KIRKLEES METROPOLITAN COUNCIL INVESTMENT & REGENERATION SERVICE

DELEGATED DECISION TO DETERMINE APPLICATIONS FOR CONSENT, AGREEMENT OR APPROVAL REQUIRED BY CONDITION

Reference No:	2025/44/91051/E
Site Address:	Shawcross 170, Churwell Vale, Shawcross Business Park, Dewsbury, WF12 7RD
Description:	Discharge of details reserved by conditions 4 (Acoustic Barrier), 5 (Noise Mitigation Scheme), 6 (Noise Control) on previous permission 2023/93486 for reconfiguration of building, re-orientation of car parking and service yard, erection of a noise barrier and external alterations
Recommending Officer:	Nina Sayers

Officer Report

Figure 1 – Edward Architecture plan showing the required location of the Acoustic boundary fence (Plan Reference: 1111-EA-AP004B)

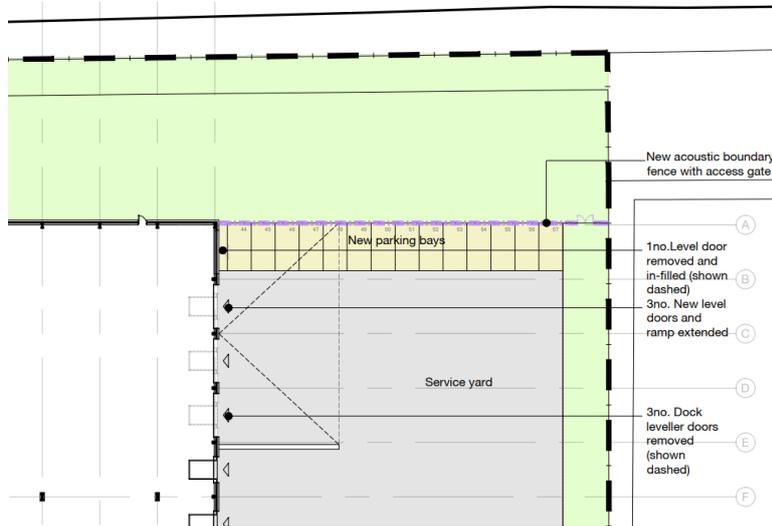
The document shows details of a 3m high timber fence which appears to be located in the same location as specified in figure 6 of the Noise Impact Assessment identified within the condition. The document also provides photographs showing that this has been installed. However, the details are not definitive to confirm the fence has been installed in the correct plan, nor to the required standard.

While the above is acknowledged, the information provided is not considered definitive to confirm whether the fence is fully in the correct location, nor to the correct specification, as required by condition.

Photo 1 – Acoustic barrier evidence

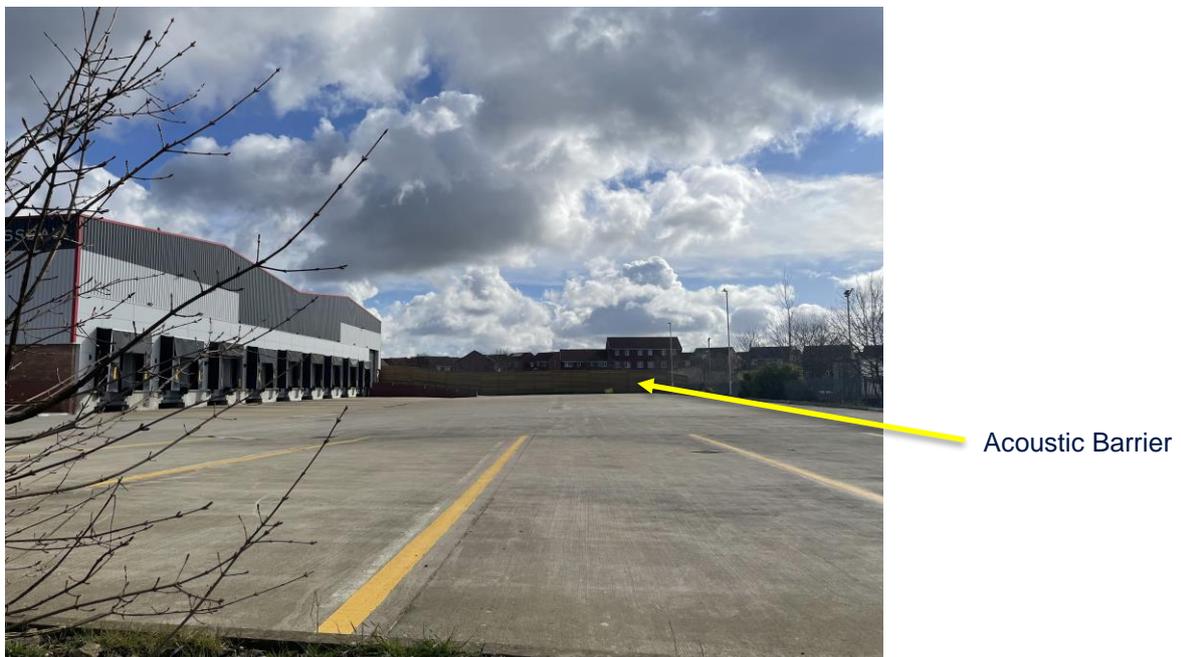
The document shows details of a 3m high timber fence which appears to be located in the same location as specified in figure 6 of the Noise Impact Assessment and provides photographs showing that this has been installed.
